Statement of Case of the Local Planning Authority (Kirklees Council)

Statement dated 15th August 2023

Appeal ref: APP/Z4718/W/3324633

Site: Land adj. 21 Thomas Street, Lindley, Huddersfield, HD3 3JJ

Visibility at Site Access (Ref. 152986-001 Rev A)

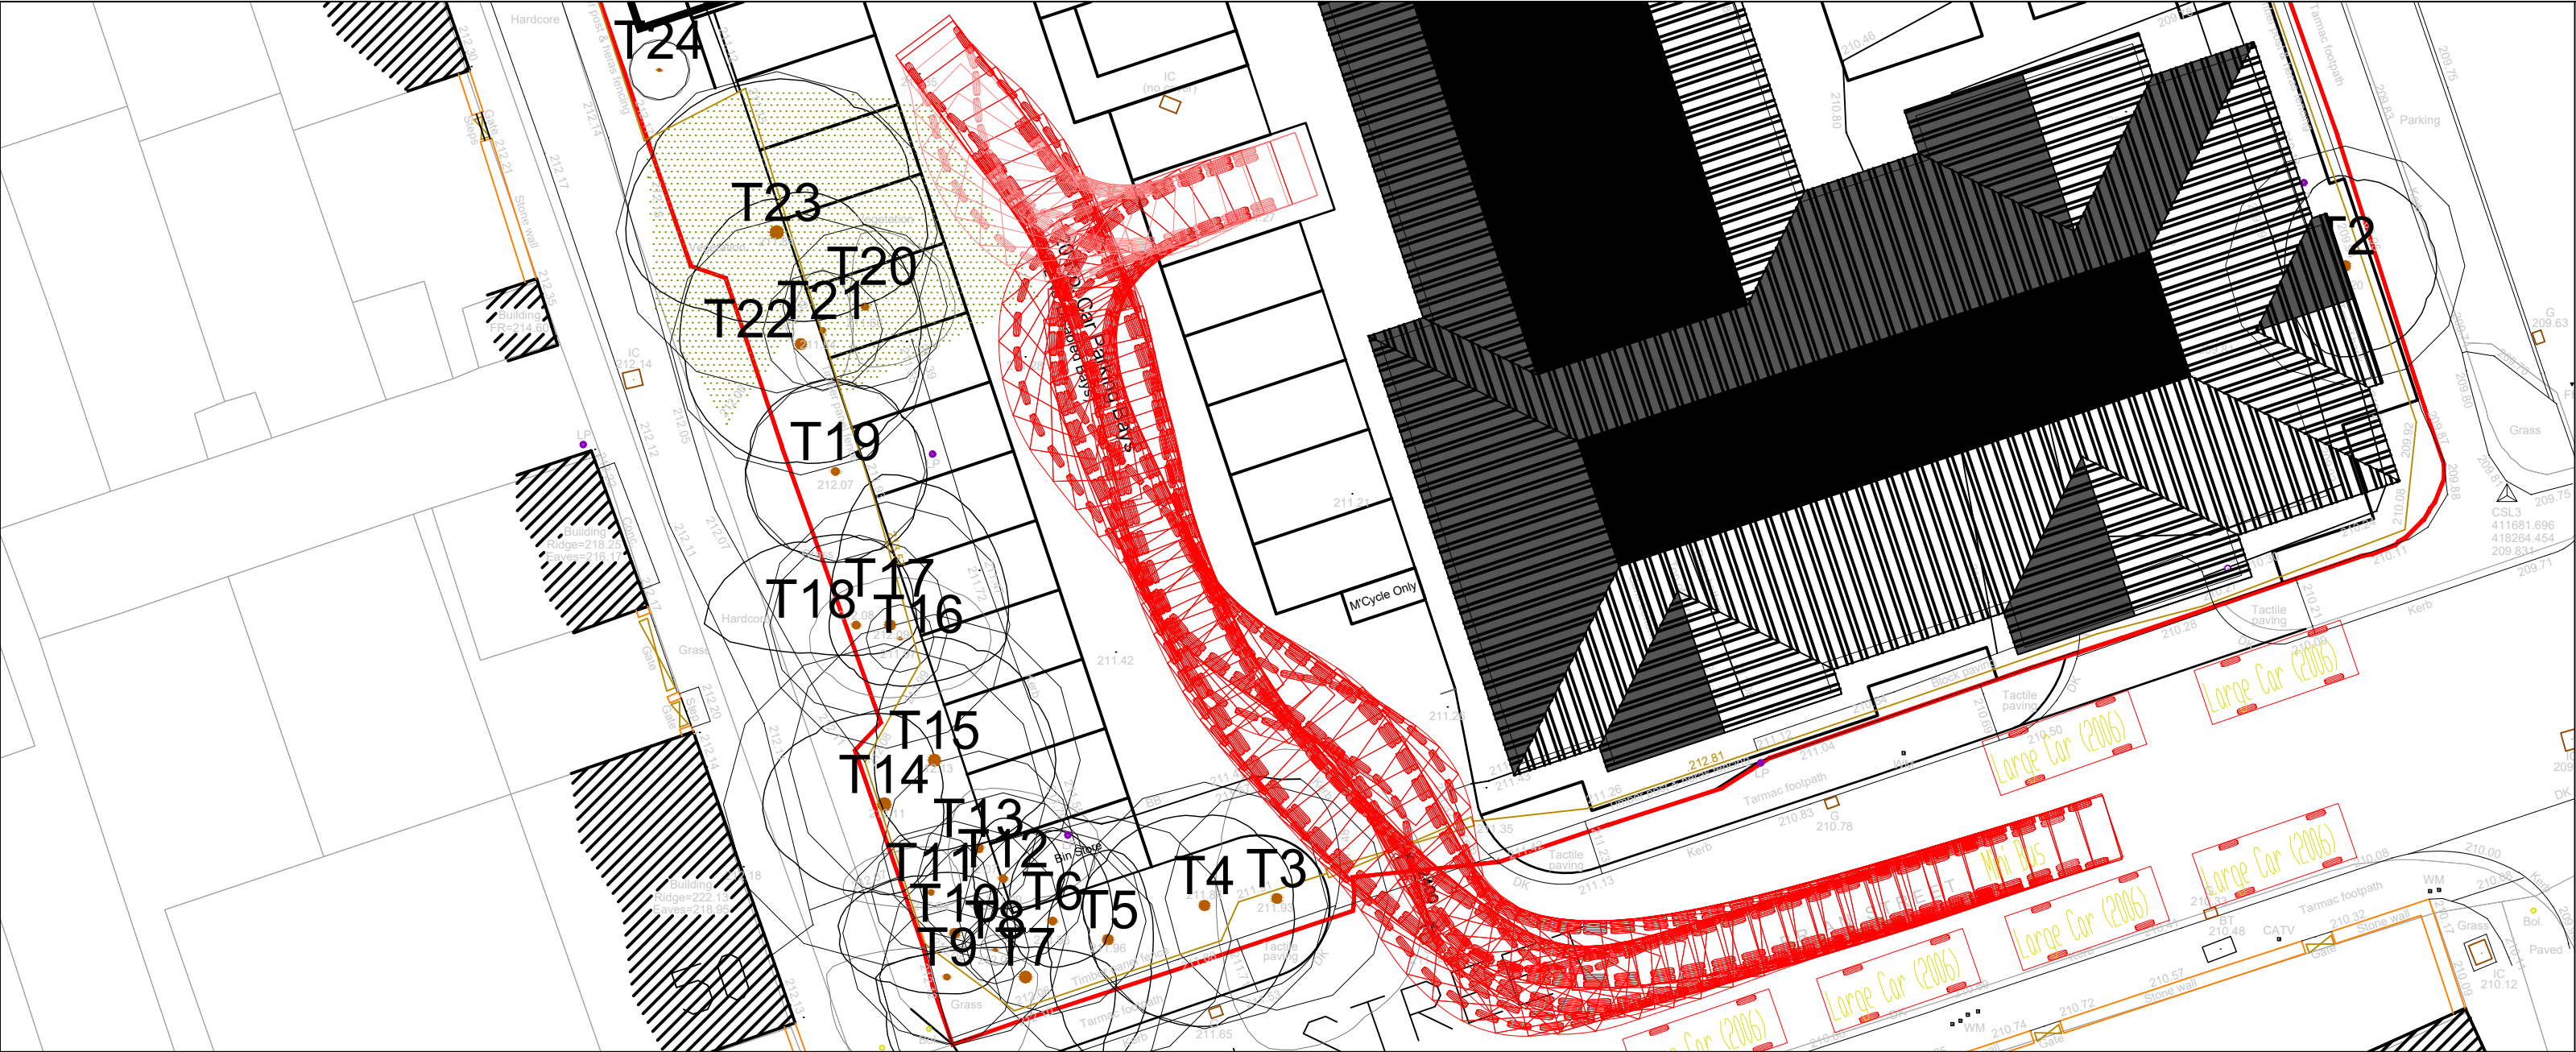
- 2.6 *Site Access – Visibility:* The Council does not dispute the results of the Appellant's Automatic Traffic Count / speed survey. It is accepted that visibility splays commensurate with the recorded 85th Percentile speeds at the new Brian Street entrance would be 32.8m to the east and 30.3m to the west. It is also accepted

that to maintain such visibility splays would only be possible as long as there were no on-street car parking for 10m to the west of the site access and 13.5m to the east of the site access.

- 2.7 The Council does however take issue with the arguments advanced in paragraphs 5.18 to 5.24 that attempt to demonstrate either that parking within the visibility splays will not occur to any significant degree, or that if it does, it would have no significant impact upon highway safety.

- 2.11 To conclude this sub-section, it is acknowledged by both parties that temporary obstructions to visibility at the Brian Street access would be liable to occur as a result of cars parking in the visibility splays. The Council disagrees concerning the extent to which this would occur, and more importantly does not accept that it would be inconsequential in highway safety terms.

- 2.26 In other circumstances, the concerns over the access from Brian Street could be overcome through the use of a planning condition requiring measures to manage parking on Brian Street (i.e. the imposition of a Traffic Regulation Order), as was done on the subsequent, successful, outline application. In this instance it is considered that to allow this development subject to a condition requiring measures of this nature would serve no useful planning purpose. The Appellant’s position is that this is unnecessary and it is their wish to obtain a permission that does not require them to undertake such operations. For the Inspector’s assistance, the wording of Condition (5) is reproduced here. It is not however been incorporated into the list of conditions that the Local Planning Authority wishes to have imposed in the event of the appeal being upheld.

5. Prior to the commencement of development, a scheme detailing measures to manage parking on Brian Street to either side of the site access and all

associated works, together with appropriate Safety Audits, shall be submitted to and approved in writing by The Local Planning Authority. Unless otherwise agreed in writing no part of the scheme shall be brought into use until the approve scheme has been implemented.

Swept Path Analysis (Ref. 152986-002 Rev A and 152986-003 Rev A)

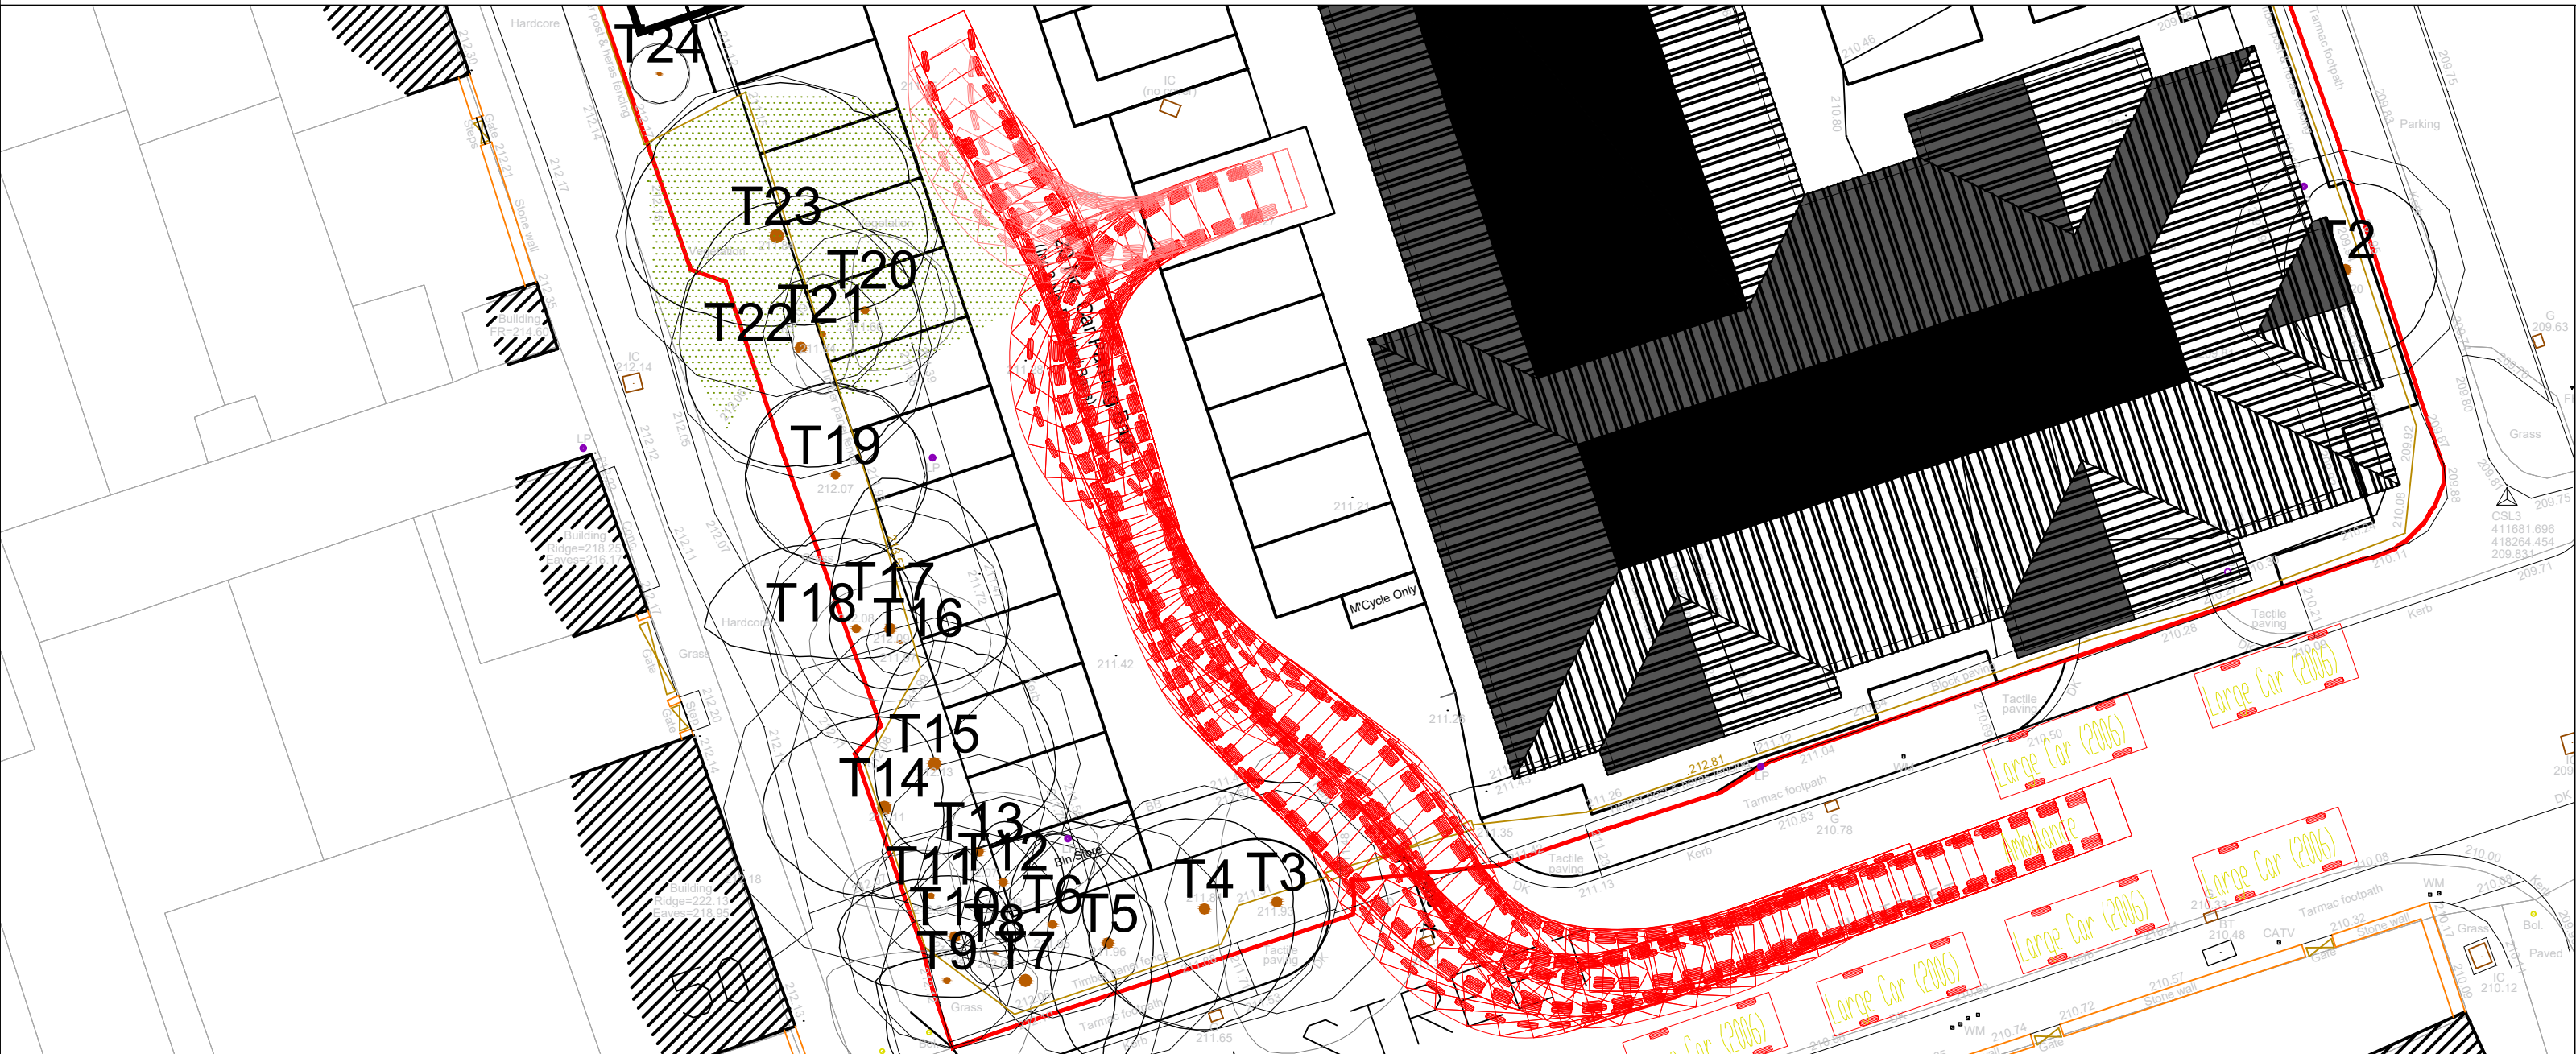
- 2.12 *Access for emergency and service/delivery vehicles:* Sanderson Associates' drawing (appendix 5), showing swept paths for a minibus and ambulance is noted. On the basis of that drawing, it is not disputed that a minibus or ambulance, or an even larger vehicle if required, would be able to gain access and egress to the site via Brian Street in forward gear. This does not overcome the Council's concerns about visibility that form a key part of the reason for refusal.

- 2.14 In short, it is accepted that emergency and service vehicles using the Brian Street entrance would, in practical terms, be able to enter the site, turn, and leave in forward gear. The Council does not accept that such vehicles will be able to "safely enter and exit the site" because the Council's principal safety concern over the use of the Brian Street access, namely visibility, has not been overcome.
